OUT21/3155

**Oxley Solar Farm (SSD-10346)
EIS**

Liz Rogers
Manager, Assessments, Knowledge Division
Department of Planning, Industry and Environment: Water
9 April 2021

Figure 7-3 Dams and watercourses (including Strahler stream order) present on the proposal site.

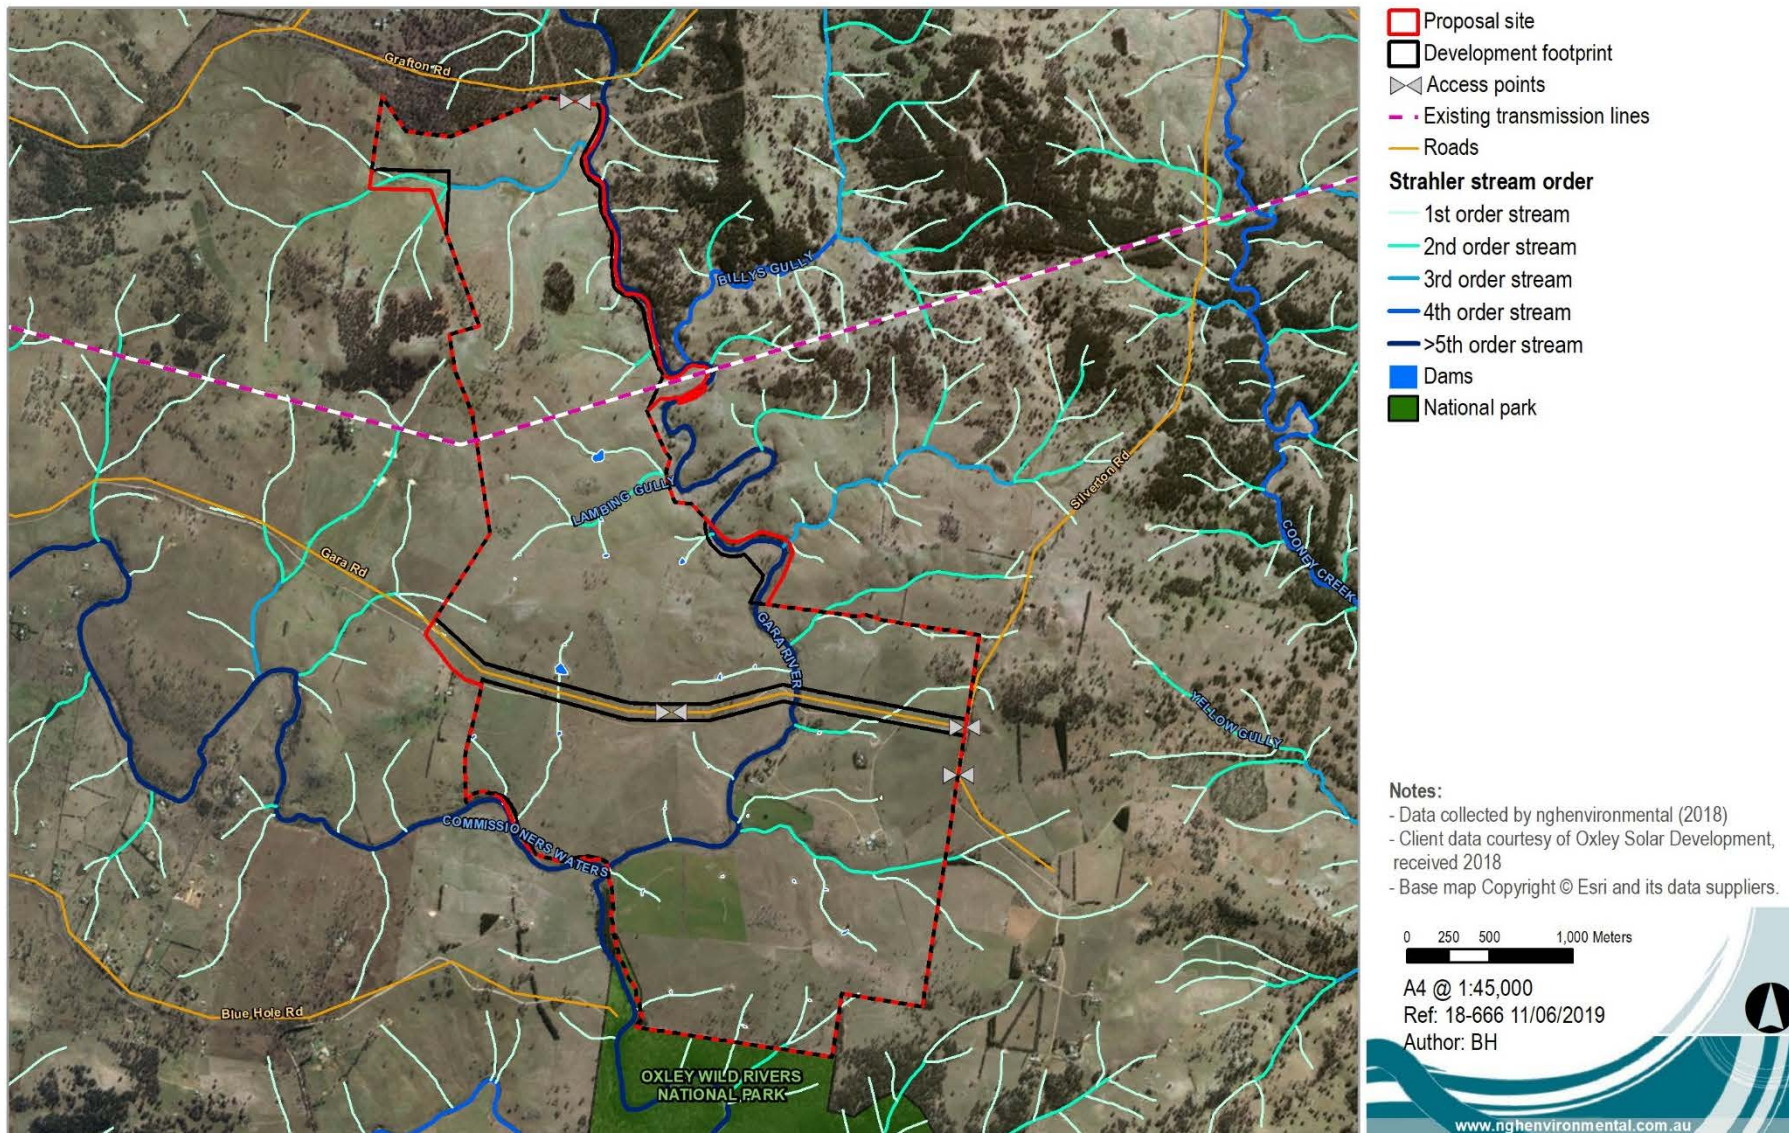
- Following the land subdivision, the size of farm dams needs to be reviewed to ensure the dam size does not exceed the Maximum Harvestable right Dam Capacity (MHRDC) for each landholding. If the MHRDC is exceeded the dams will need to be resized or relevant approvals and licences sought under the *Water Management Act 2000*.
